WEST SUSSEX COUNTY COUNCIL CONSULTATION

TO:	Arun District Council FAO: Andrew Wood
FROM:	WSCC - Highways Authority
DATE:	3 June 2019
LOCATION:	2 Croft Cottages, Pier Road, Littlehampton, BN17 5LS
SUBJECT:	LU/159/19/PL New maisonette over parking area, extend crossover & alterations to rear fenestration.
DATE OF SITE VISIT:	N/A
RECOMMENDATION:	Advice
S106 CONTRIBUTION TOTAL:	£N/A

Scale A1=1:50, A3=1:100 Drawn JHL Date 07/03/19										
19023-401										
C										
40m

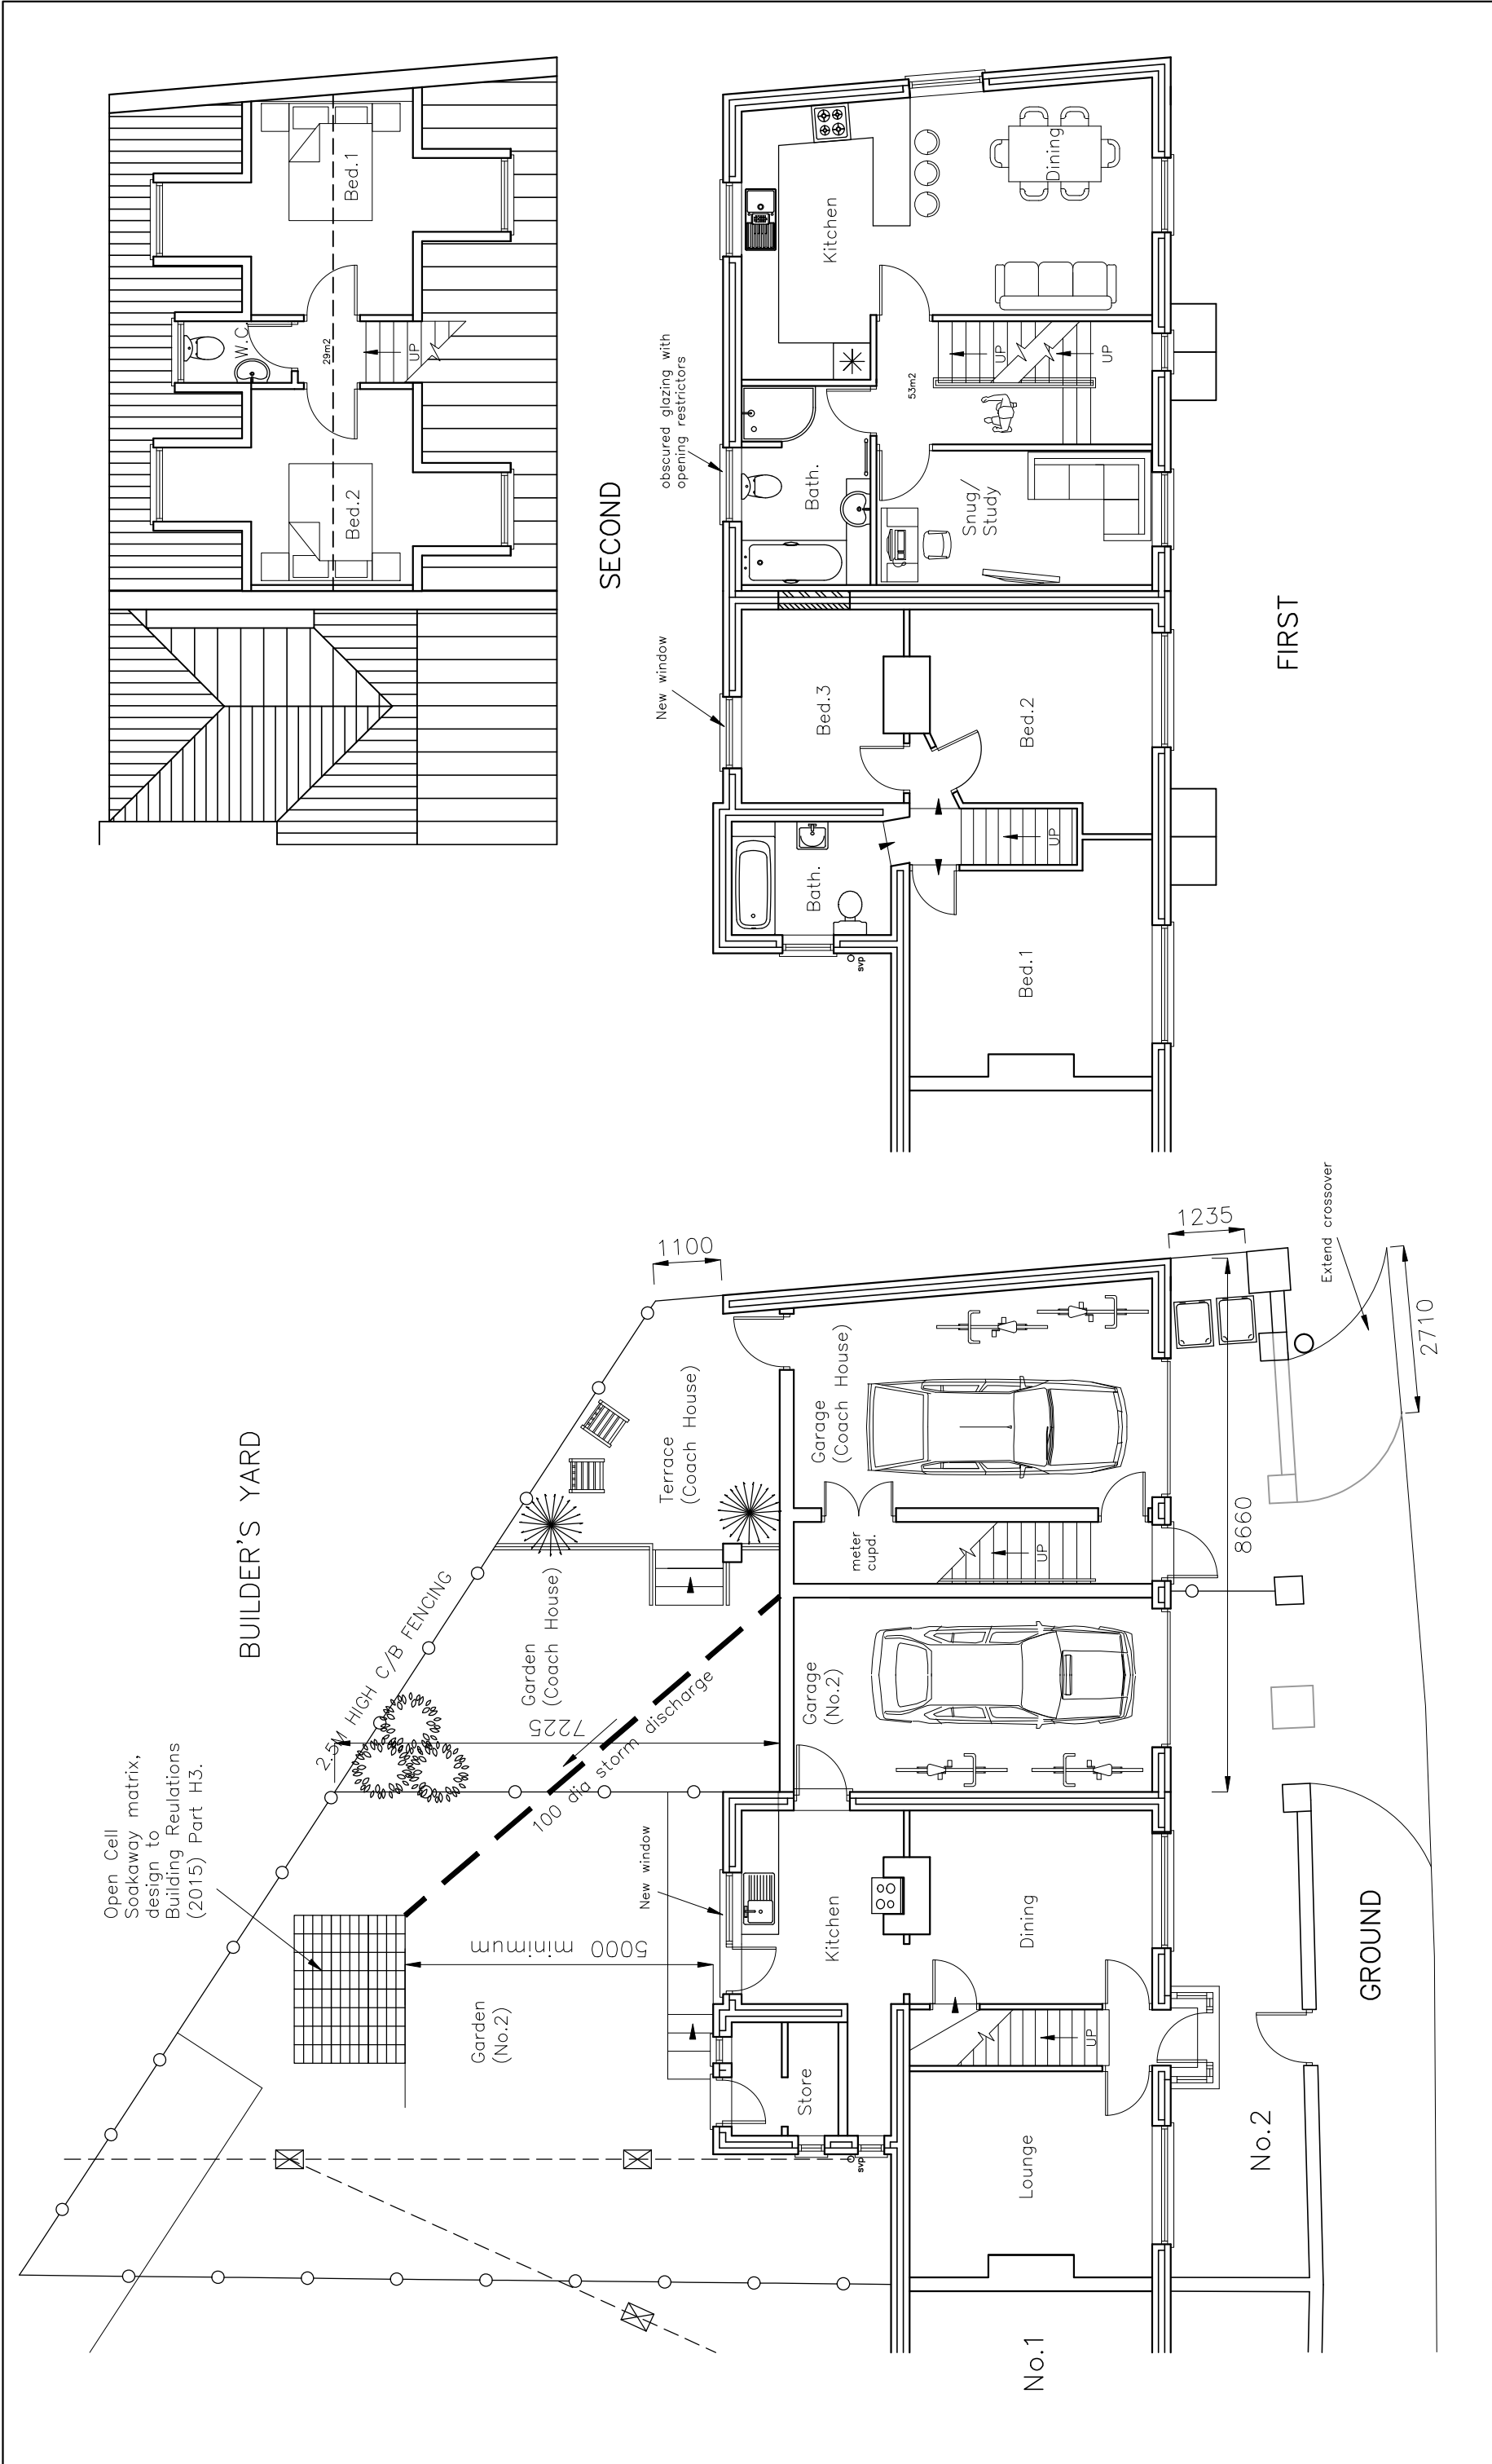
2 garages are proposed for the properties, with 1 garage serving the existing property and 1 garage for the proposed property. The garages demonstrated in the plans do not meet minimum internal dimensions for single car garages of 3m x 6m, as set out in Manual for Streets (MfS). For garages to be considered for parking provision, it is recommended that the applicant revises the dimensions of the garages to meet MfS minimum internal dimensions.

Block Plan: 1:500

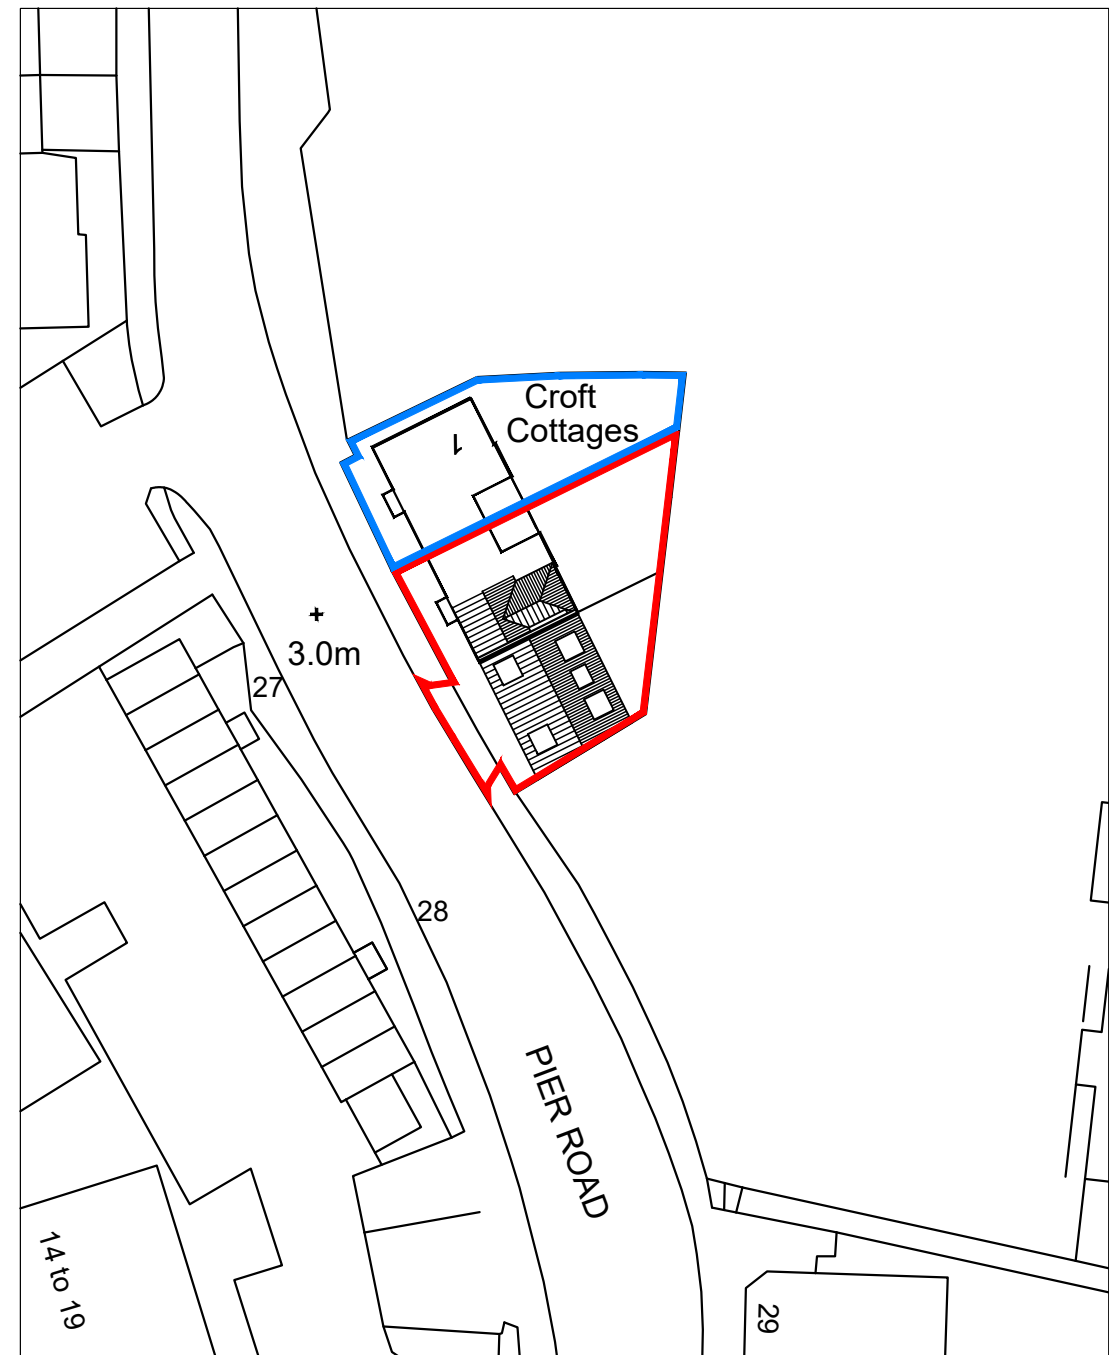
The proposed widening of the drop down kerb would be subject to a licence and constructed to a specification agreed with the Local Highway Engineer. Whilst the LHA does not raise any highway safety objection to a wider VCO in this location, the applicant should be aware that the Local Highway Engineer is unlikely to grant a licence for a Vehicle Crossover (VCO) wider than 6.4 m. The applicant should consider reducing the proposed VCO to a maximum width of 6.4m.

Street lights must be situated at least 1.5m from the location of the top of the ramped kerb of the proposed crossover. The crossover works will require the relocation of the street light located on publically maintained highway fronting the application site. These relocation works would need to be undertaken at the expense of the applicant. It is the responsibility of the applicant to liaise with the necessary parties to organise the moving of the street light. The street light will need to be relocated at least 1.5m from the location of the top of the ramped kerb of the proposed crossover.
